Ribble Valley Borough Council
Housing & Development Control

Application no: **3/2023/0586**

Address: **Root Farm Dunsop Bridge Clitheroe BB7 3BB**

Proposal: **Approval of details reserved by conditions 4 (solar panels), 6 (landscaping), 8 (construction management plan/method statement), 11 (highway works) and 16 (service management plan) of planning permission 3/2021/0952.**

6.07 SITE TRAFFIC MANAGEMENT PLAN

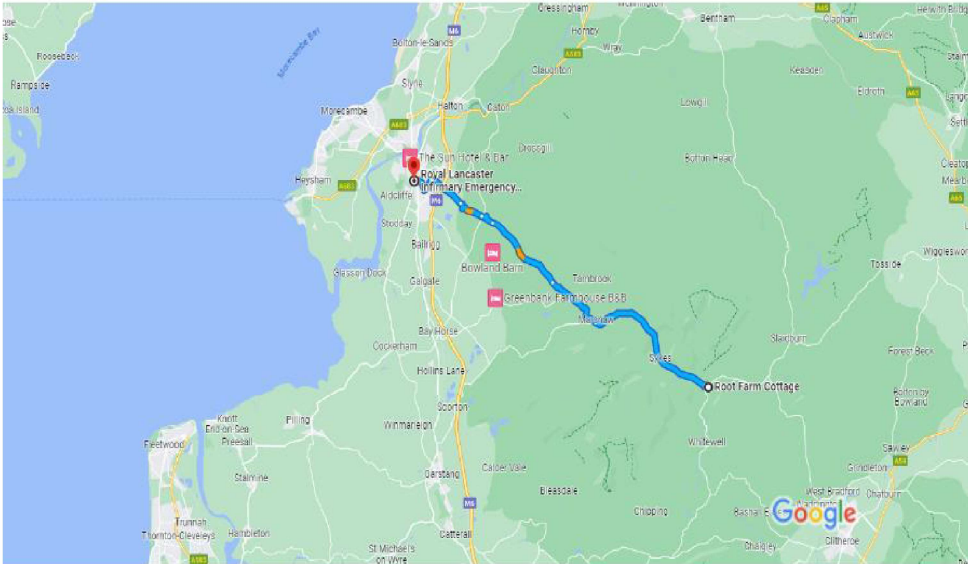
The LHA have reviewed the Construction Management Plan and require a Traffic Management Plan to be submitted showing where the temporary construction signs will be implemented along the adopted highway, before this condition can be discharged. The temporary construction signs should comply with the guidance supplied with Chapter 9 of the Traffic Signs Manual.
